Barnaderg Cooloo Windfarm Action Collective CLG

To	Sinead White, Executive Officer, An Coimisiún Pleanála - 64 Marlborough Street, Rotunda, Dublin 1, D01 V902
From	The Secretary, Barnaderg Cooloo Windfarm Action Collective CLG - Cooloo, Moylough, Co Galway
Your Ref	PAX07.323761 – Cooloo Wind Farm
Re	Response to Applicants Response to Submissions
Date	9th July 2026

Submission to An Coimisiún Pleanála in relation to Cooloo Wind Farm ACP Ref. 323761

Prepared in response to the Commission's letter dated 5 June 2026 inviting submissions on the Applicant's responses to third-party observations and the Galway County Council report.

Figure 4: County Galway Wind Energy Zoning 2022 - 2028

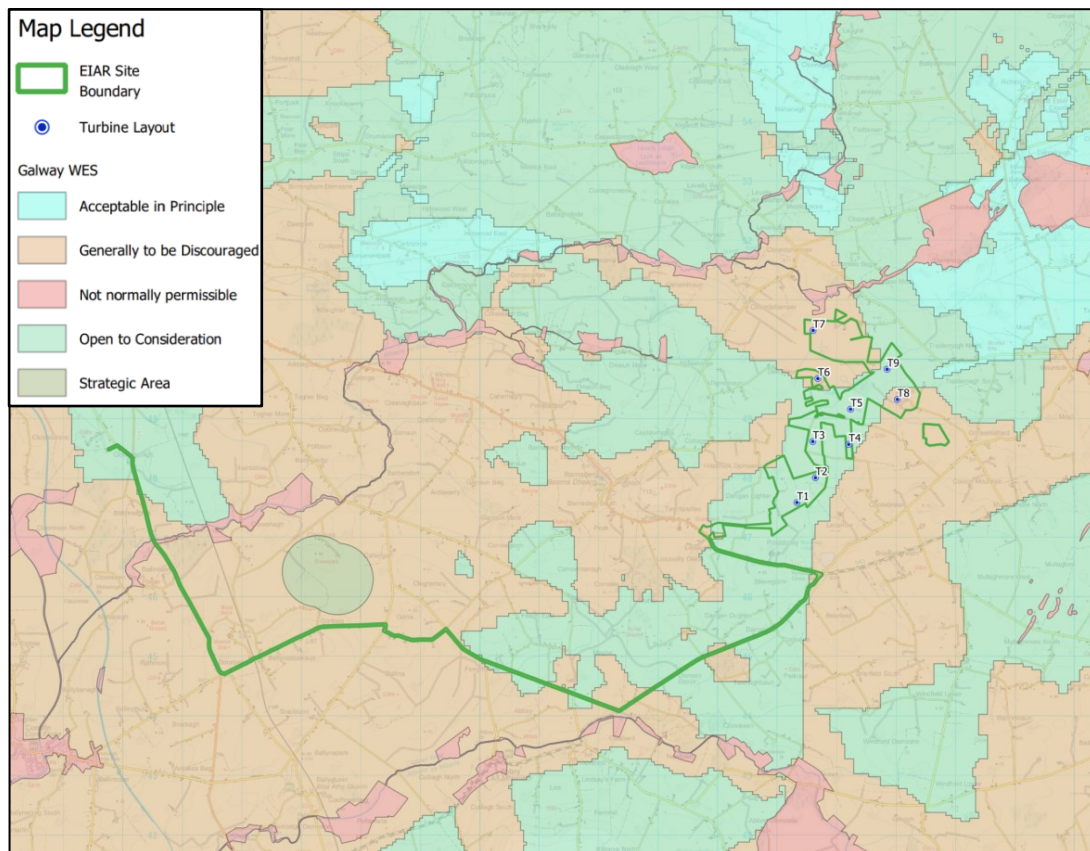
The applicant does not overcome the local policy conflict.

The applicant acknowledges that observers raised the fact that part of the application site is designated as "Generally to be Discouraged" for wind energy development. The response attempts to minimise this by stating that the LARES does not specifically prohibit applications in such areas and that the proposal should be assessed on its merits. This is not an adequate answer. A "Generally to be Discouraged" designation is a material policy constraint. It cannot be treated as neutral simply because an application is not automatically prohibited.

A case-by-case assessment must still begin from the policy position adopted by Galway County Council. The applicant has not demonstrated, within this response, why a site within a discouraged area should be treated as suitable or exceptional. It relies on a broad statement that the site "scores well" across opportunity and sensitivity factors, but the response does not reproduce the scoring, the weighting, the constraints analysis, the assumptions used, or the site-specific reasons why the discouraged classification should be displaced.
